OXFORDSHIRE COUNTY COUNCIL'S RESPONSE TO CONSULTATION ON THE FOLLOWING DEVELOPMENT PROPOSAL

Application no: 14/01932/OUT-2

Proposal: Outline - Development of up to 1,000 dwellings together with a mixed use local centre. [including A1 retail up to 1,000 m2, financial services (A2), restaurants, pubs and takeaways (A3, A4, A5), community uses (D1)]; primary school and safeguarded additional primary school land; secondary school playing field land; green infrastructure including formal (including playing fields) and informal open space, landscape and amenity space; changing and sports facilities (including D2); sustainable drainage systems; highway, cycle and pedestrian routes; car parking; infrastructure (including utilities); engineering works including ground remodelling; demolition, site reclamation and removal of structures. Formation of a new roundabout access from the A361 together with associated alterations to alignment of Bloxham Road and provision of a section of spine road through the site up to its eastern-most boundary

Transport

Project Ref	Drawing No	Rev
B14129	A_003	-

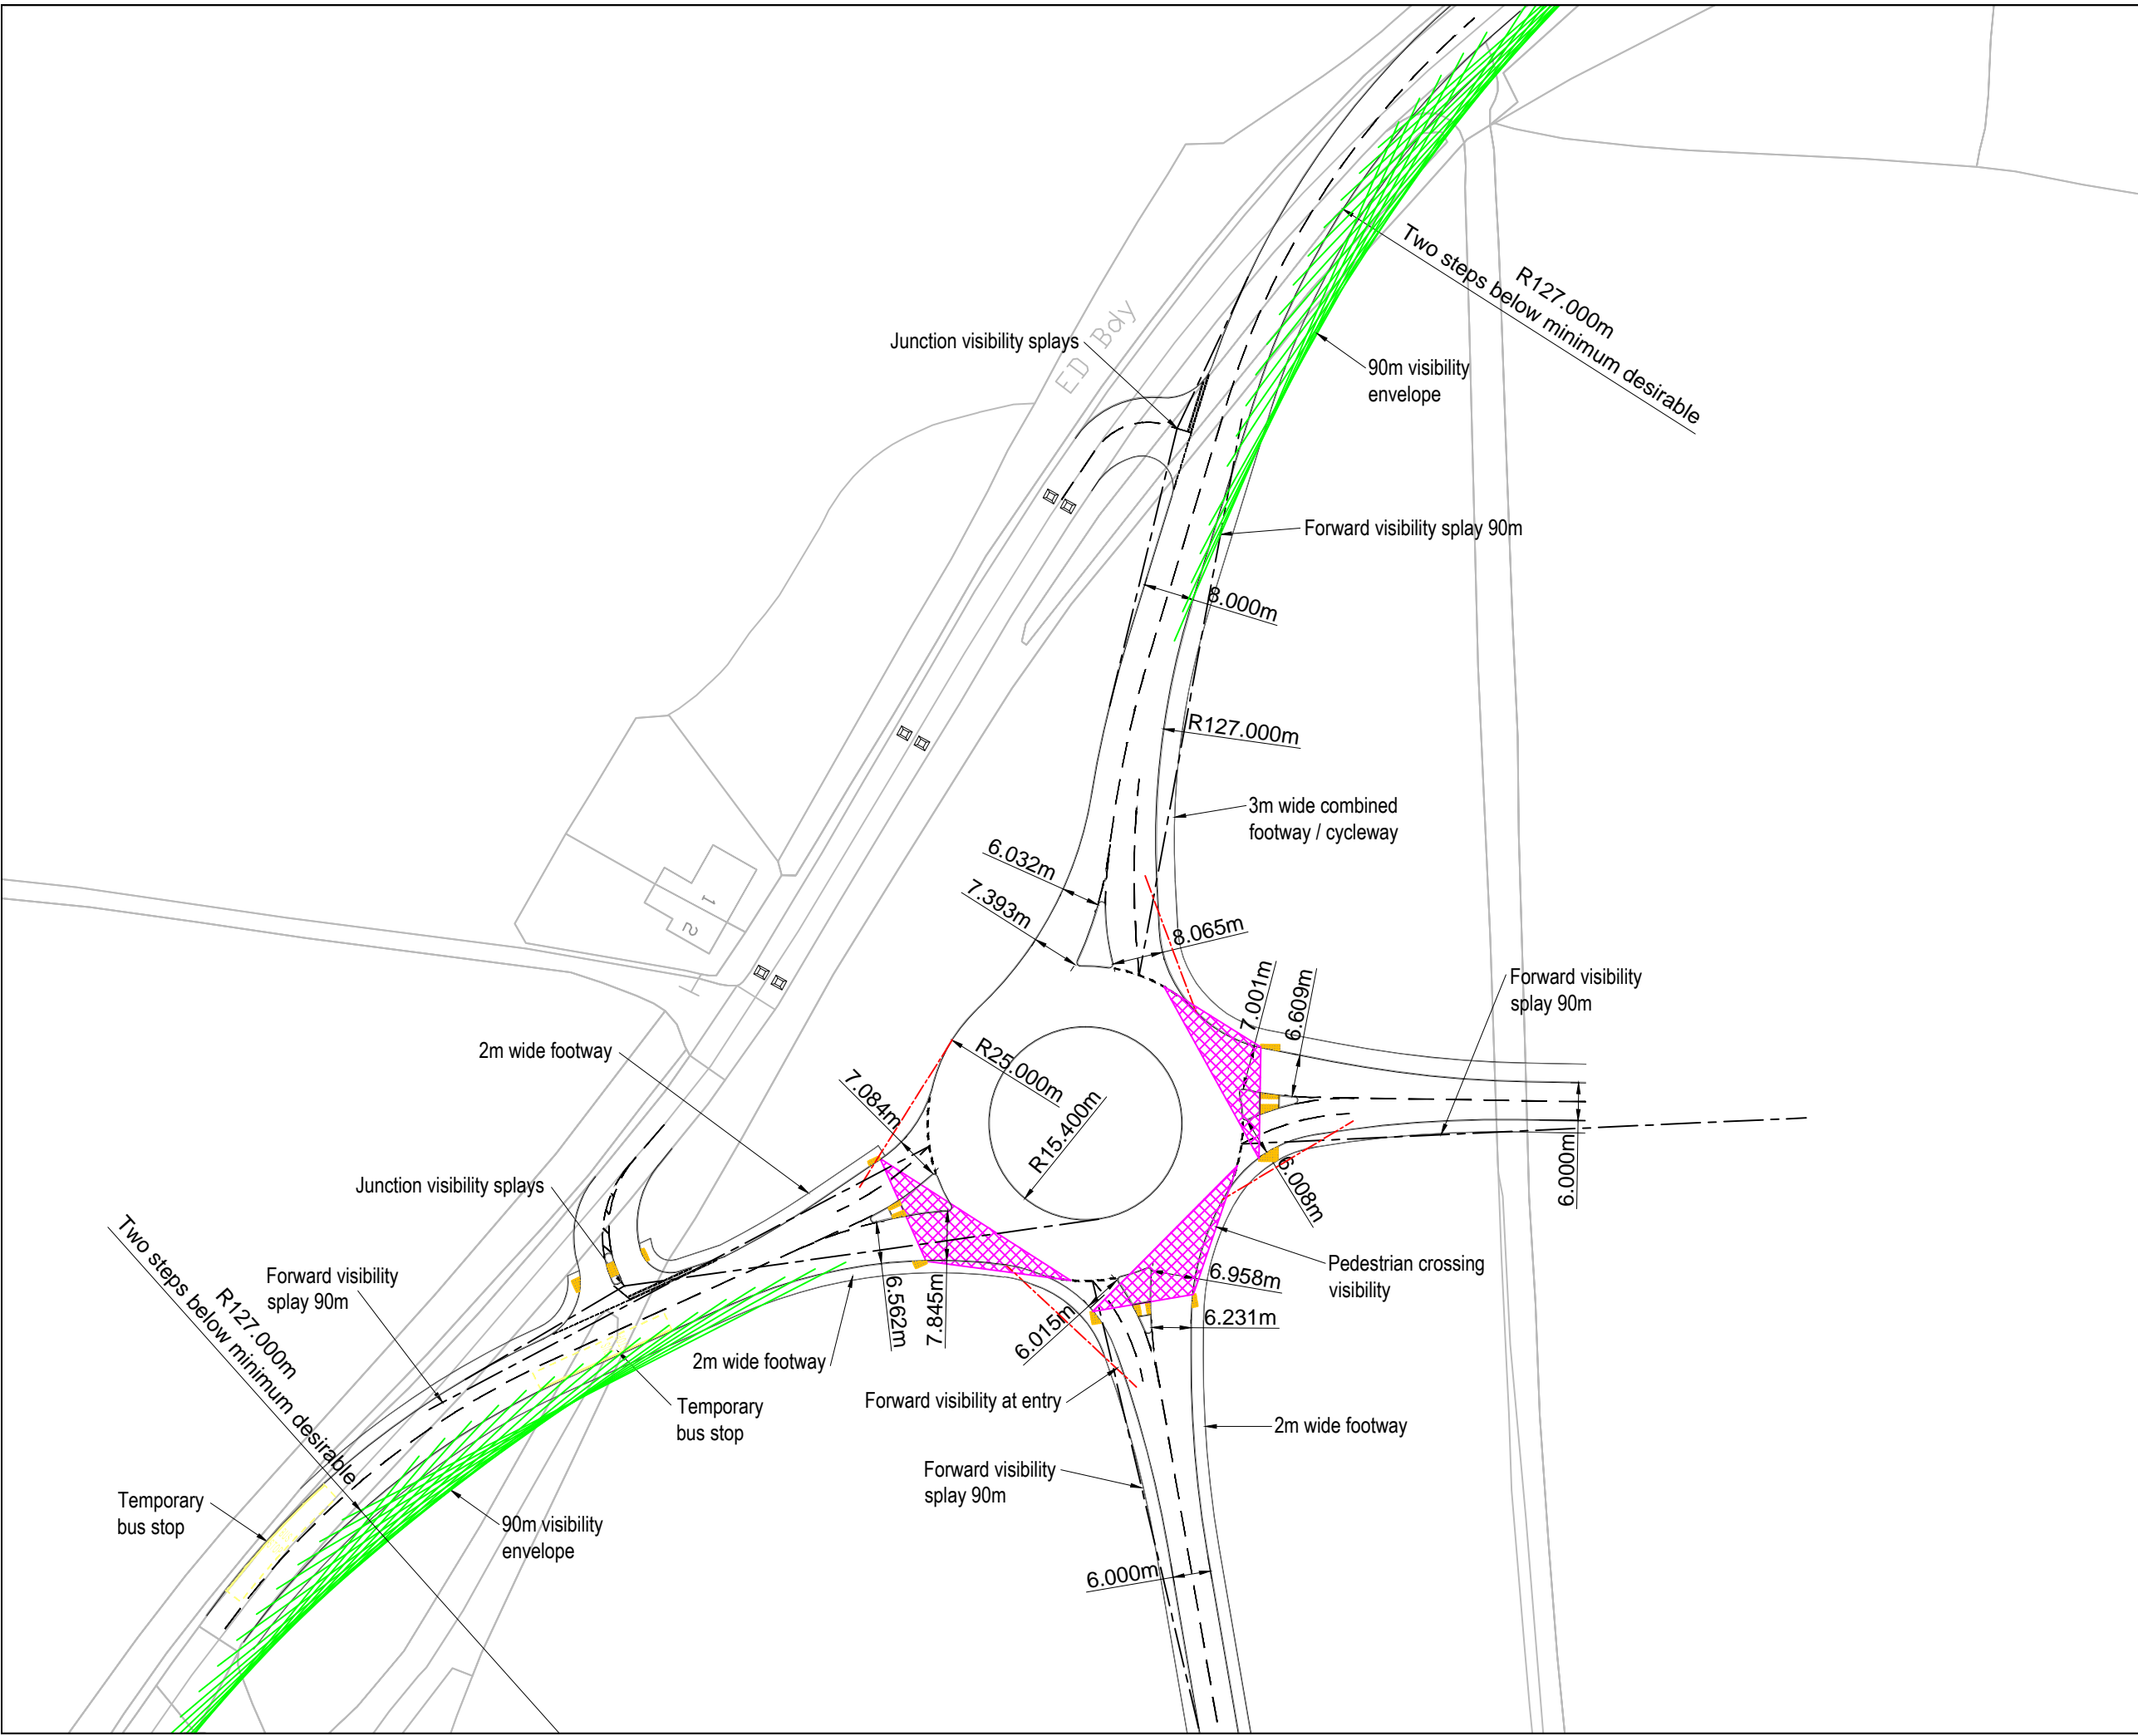
The development 14/01932/out is proposed to be accessed from a single roundabout junction where the eastern and southern arms enter the development, the western and northern arms of the junction are the re-aligned A361 Bloxham Road. The applicant has provided drawing B14129-A-003-Rev 1 to illustrate this junction.

The Appendix E of the original TA indicates that 84% of trips arising from the site will use the eastern access and 16% the southern access. However, upon further investigation of the modelling outputs, it is clear from the data for the roundabout junction (labelled as junction 16, Node: 9069) that 100% of the development traffic is accessing the development from the southern access, the secondary access. This coding will have some influence on how the model subsequently distributes traffic, and it can be seen that the spine road is lightly trafficked due to trips arising from the 14/01932/out application site are required to exit the

As stated above, the coding of this junction does not reflect the proposal for the development traffic to load 86% to the eastern access and 16% to the southern access, as 100% if coded to the southern access.
